Appeal Decision

Appeal Ref: APP/R5510/D/24/3342242

34 Leybourne Road, Uxbridge, Hillingdon UB10 9HD

- The appeal is made under section 78 of the Town and Country Planning Act 1990 (as amended) against a refusal to grant planning permission.
- The appeal is made by Ms Fengzhu Zhou against the decision of the Council of the London Borough of Hillingdon.
- The application Ref. is 7946/APP/2024/98.
- The development proposed is the erection of a front porch, single storey rear and a double storey side extension. Conversion of roof space to habitable use to include a hip to gable end extension, rear dormer and front roof lights.

PROPOSED FIRST

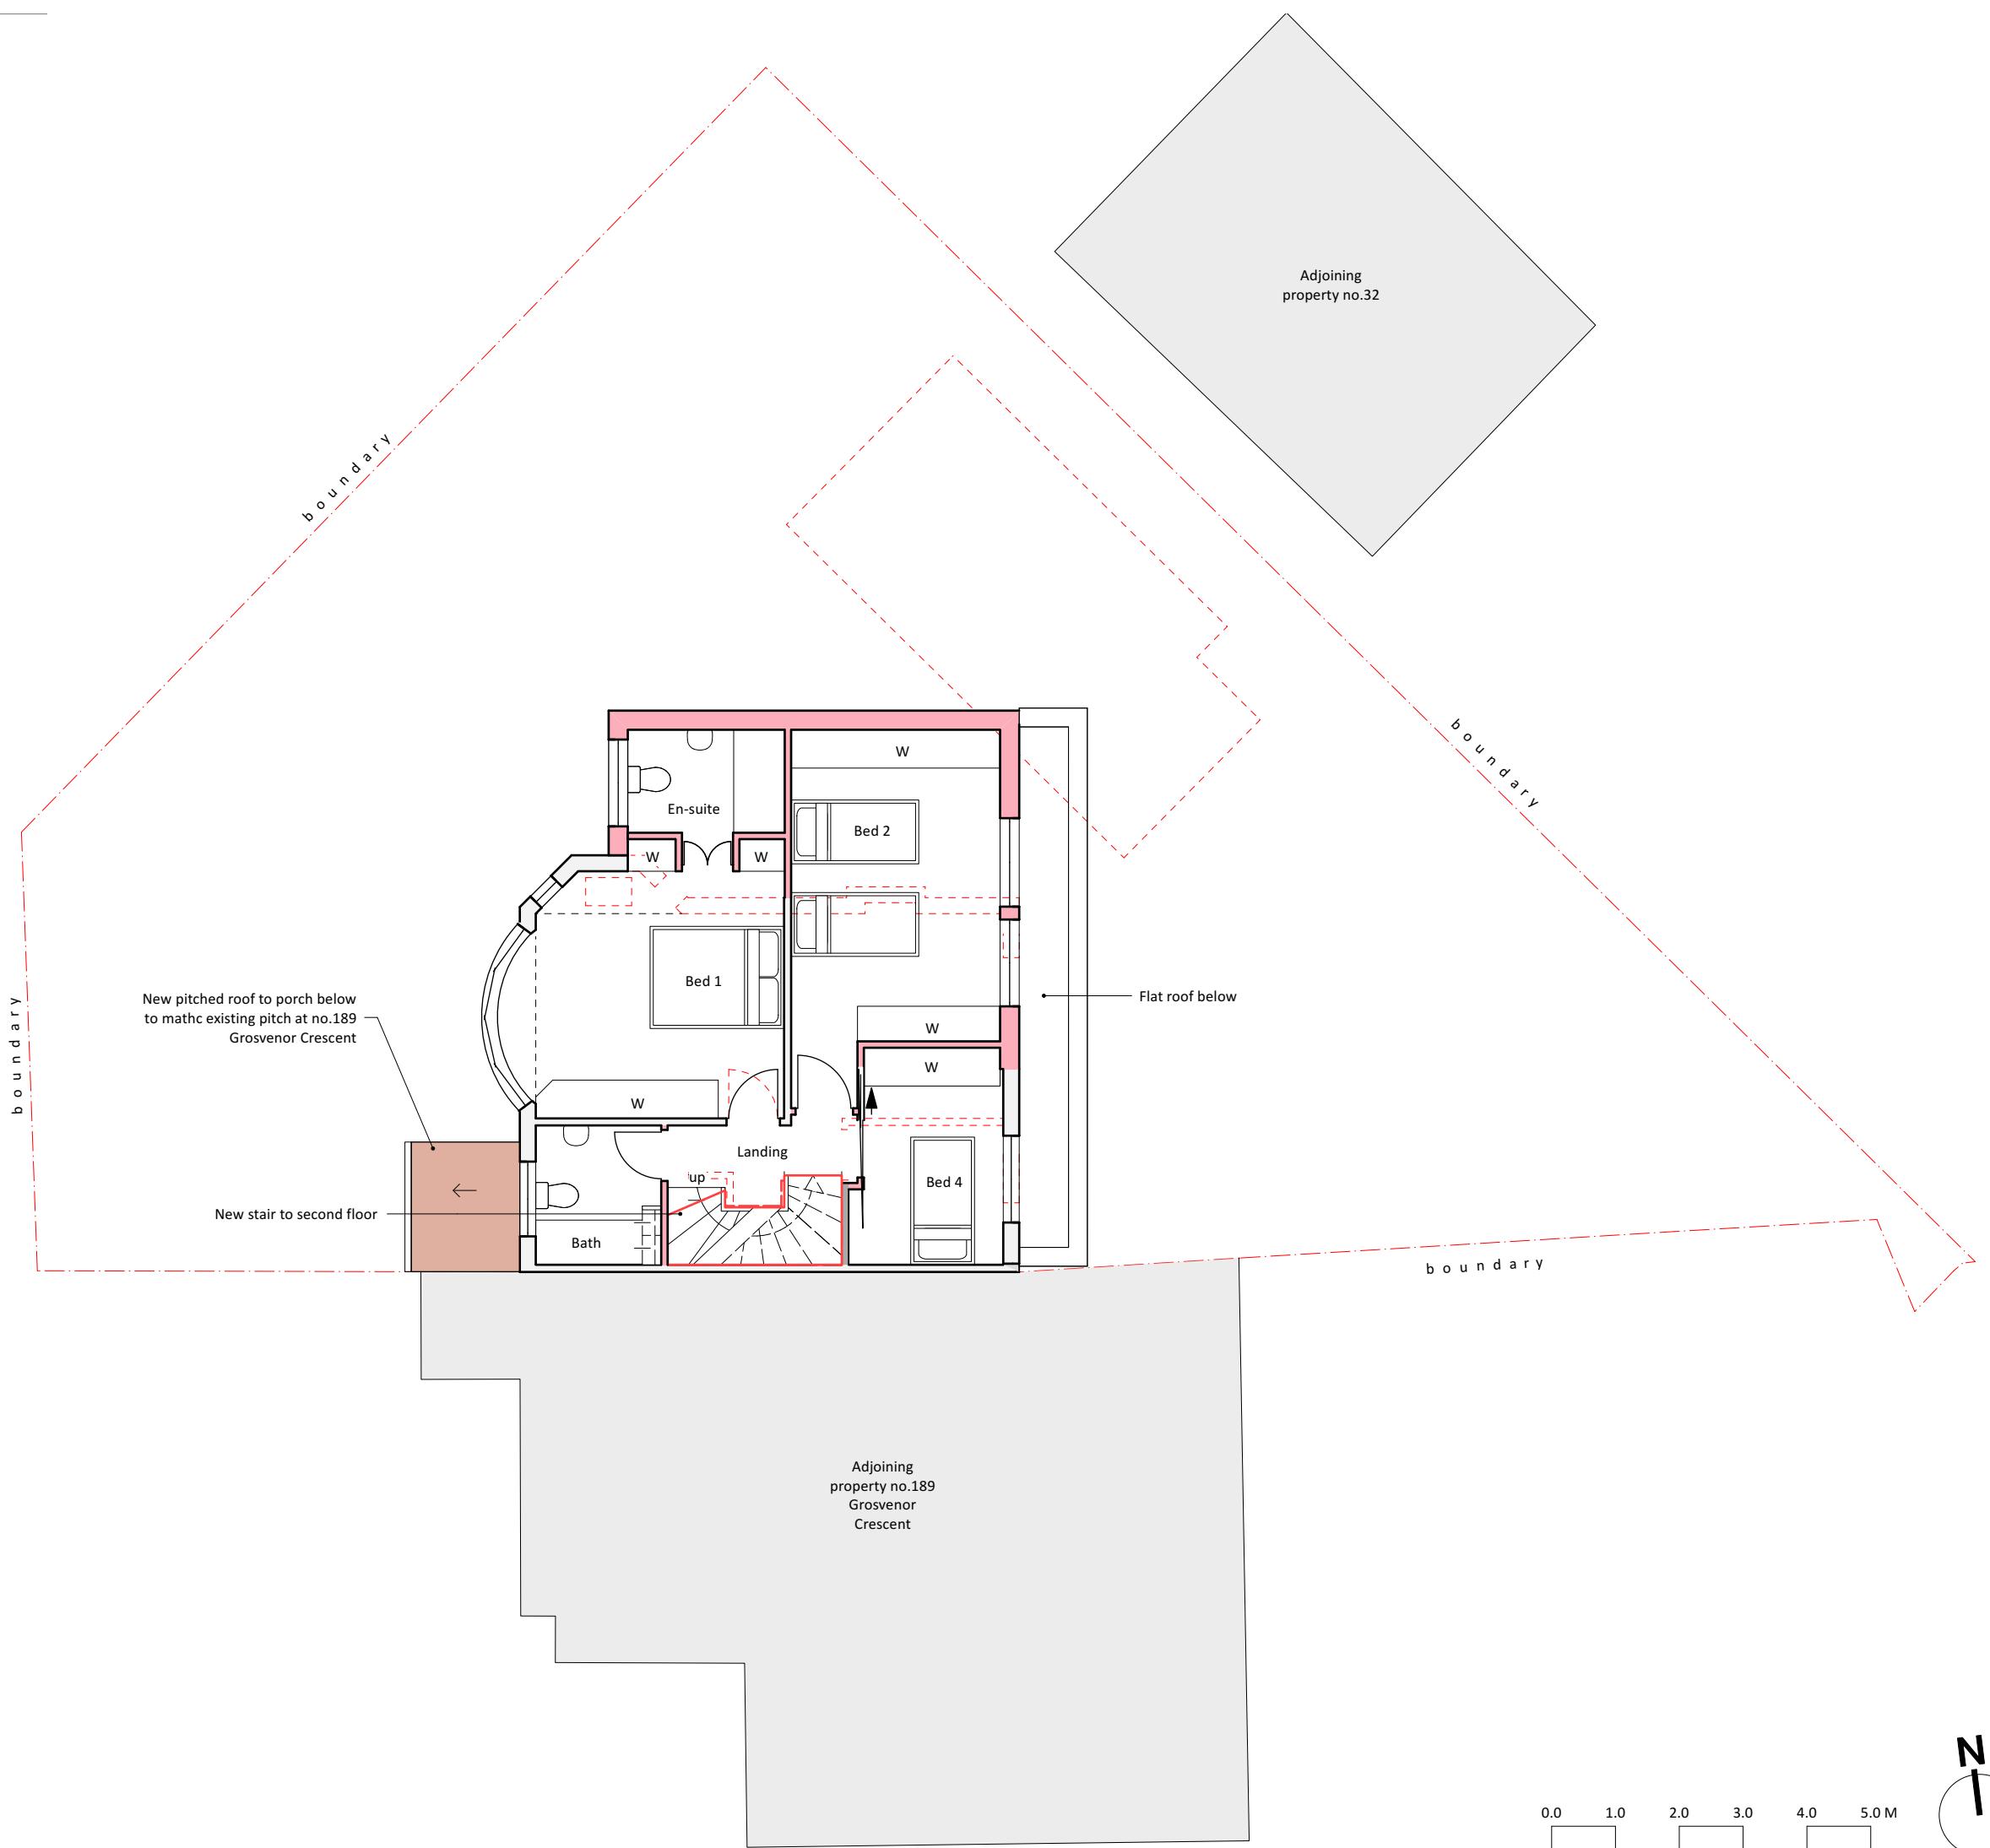
11. No hip to gable roof extension and rear dormer exist at the moment at the appeal site, but it is necessary to consider the impacts of the proposed two storey side extension with a hip to gable roof and rear dormer as shown in the submitted plans. My view is that the proposed side extension would not integrate well with main dwelling once it has had a hip to gable extension and dormer constructed (or vice versa). The side extension would appear as an add-on particularly from the rear where the side extension would not sufficiently integrate or meld with the main dwelling. This would be particularly harmful at roof level where the varied roof profiles (including the sizeable dormer cheek) would be discordant. Overall it would be unsympathetic to the original architectural composition of the host dwelling.

DRAWING PROPOSED ROOF

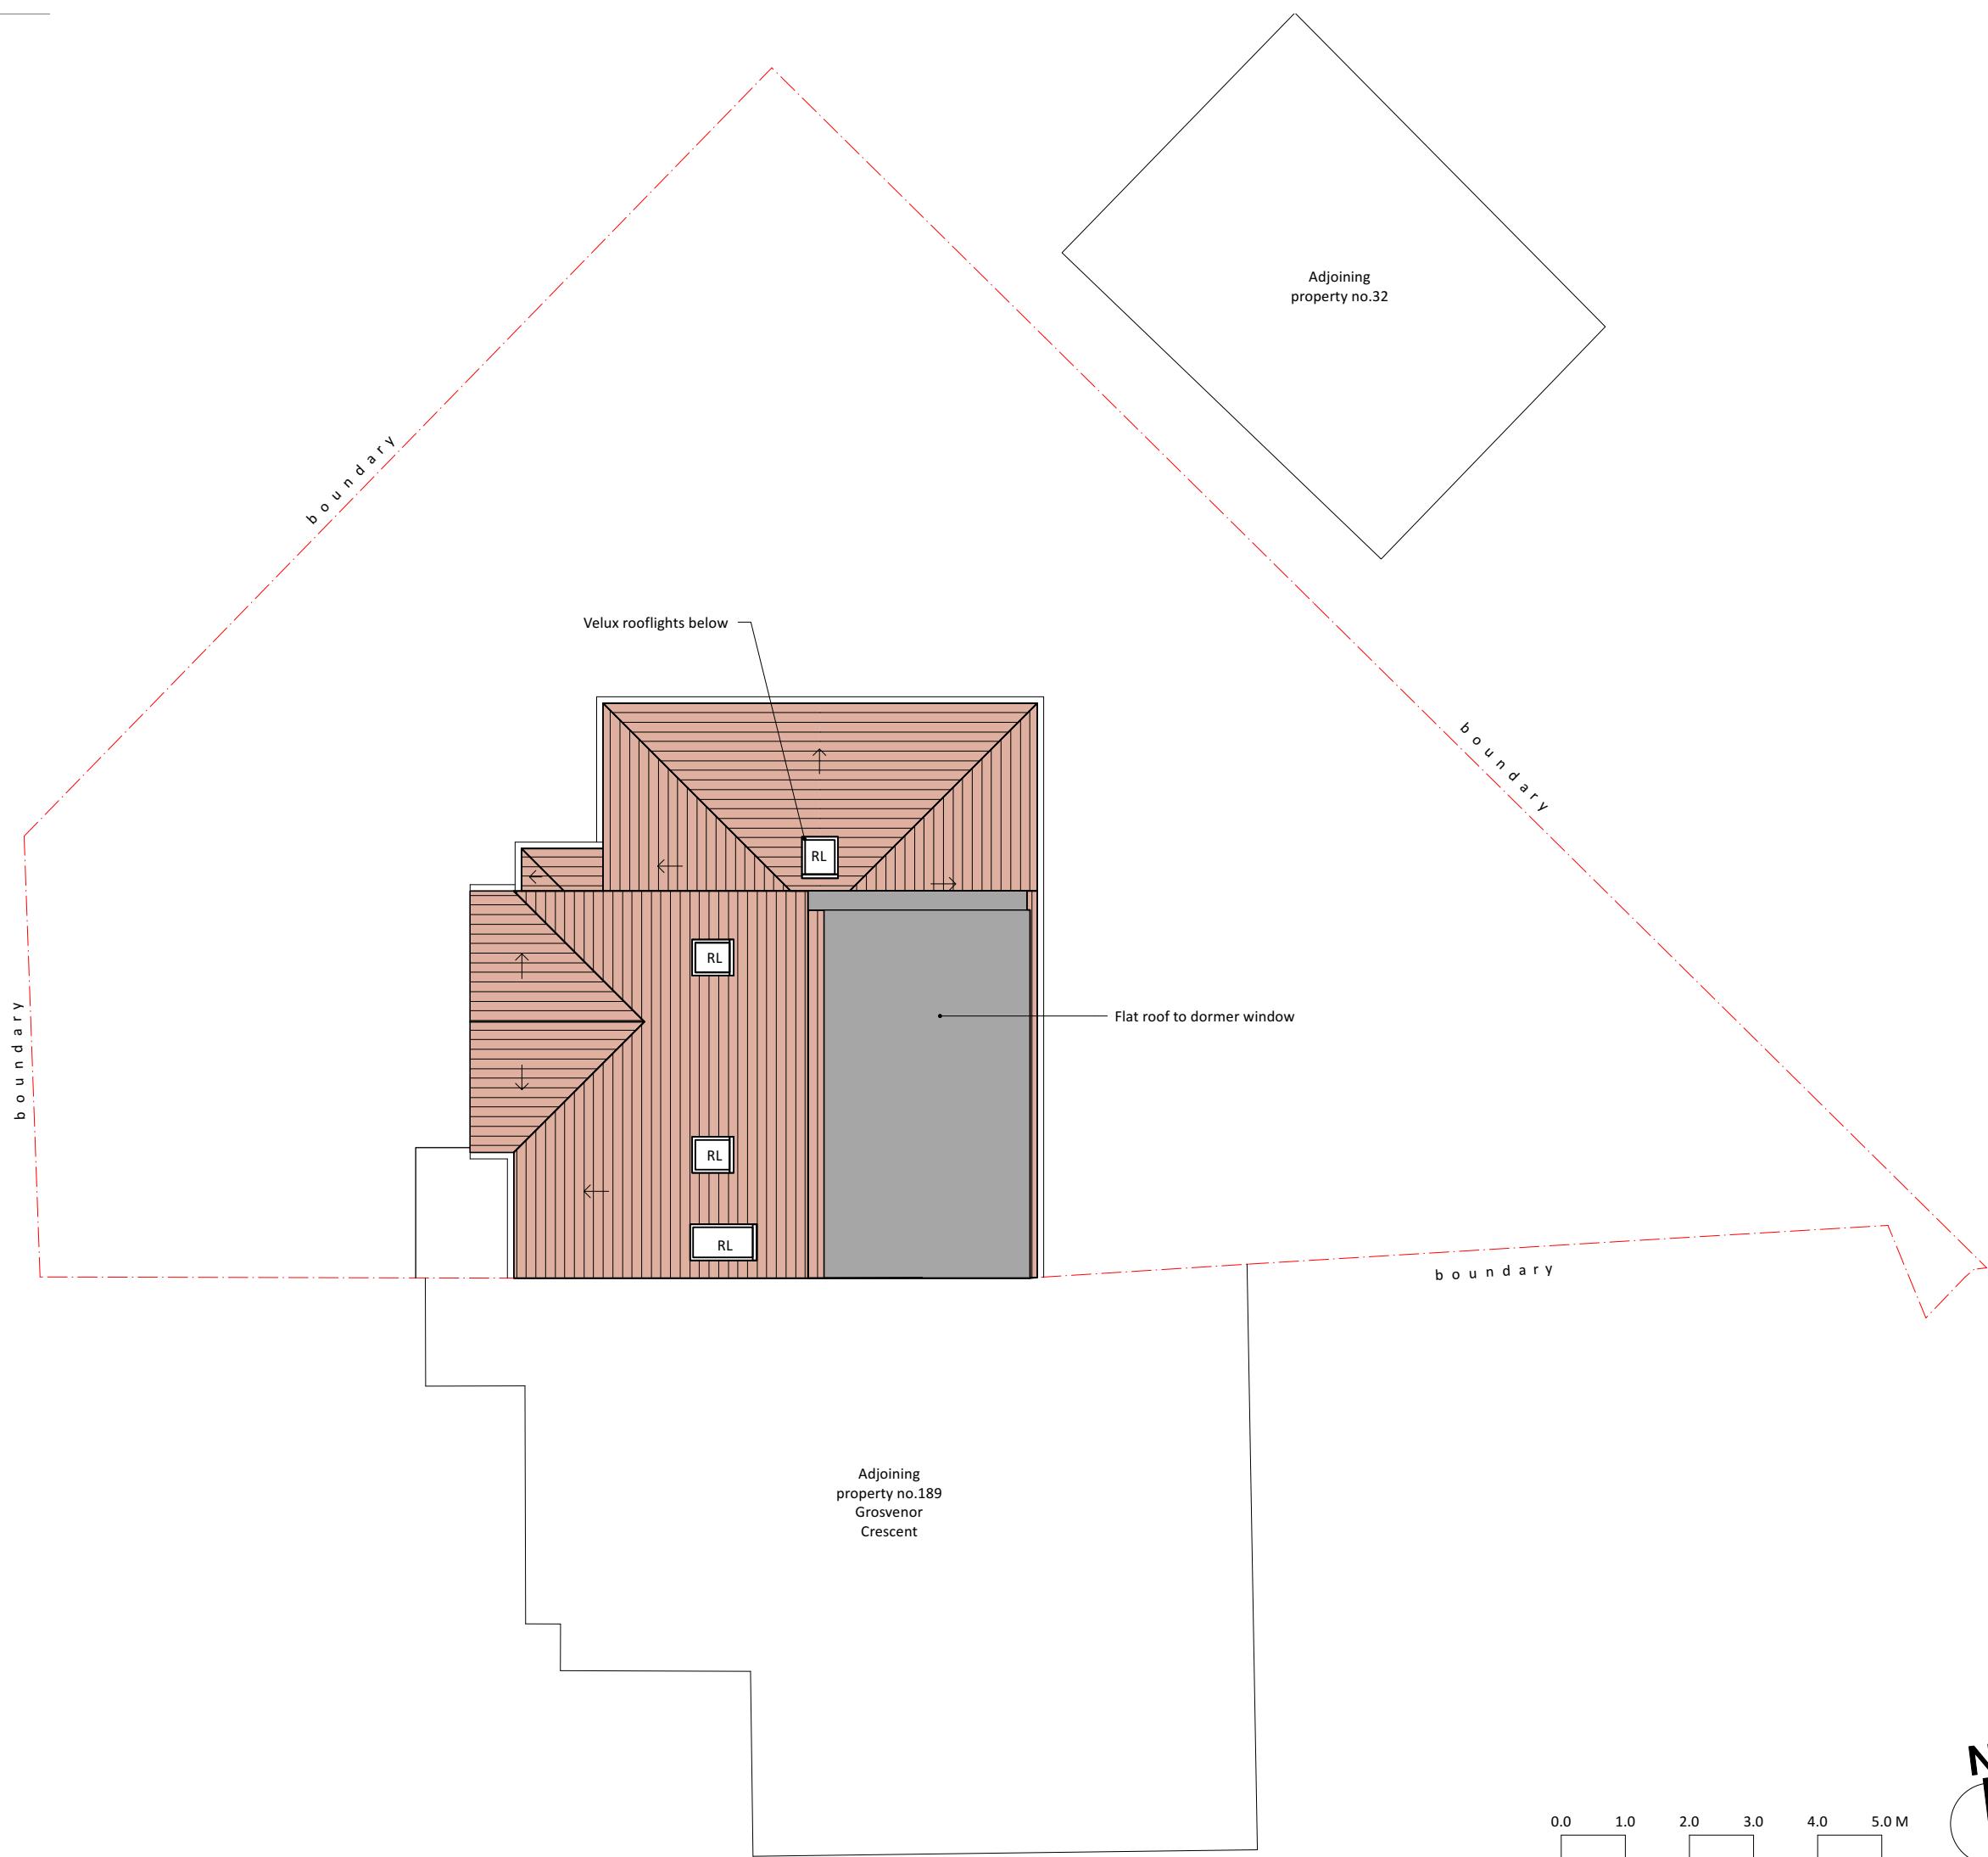
12. In addition, the cumulative effect of the proposed roof extension/dormer and the double storey side addition, would result in a disproportionate addition which would appear overly bulky and would fail to be subordinate to the original dwelling. They would add to the lack of balance between the appeal property and its semi-pair and owing to the prominent corner plot the proposed development would be readily visible in the streetscene and tend to draw the eye, to the detriment of the pleasant rhythm of the streetscene.
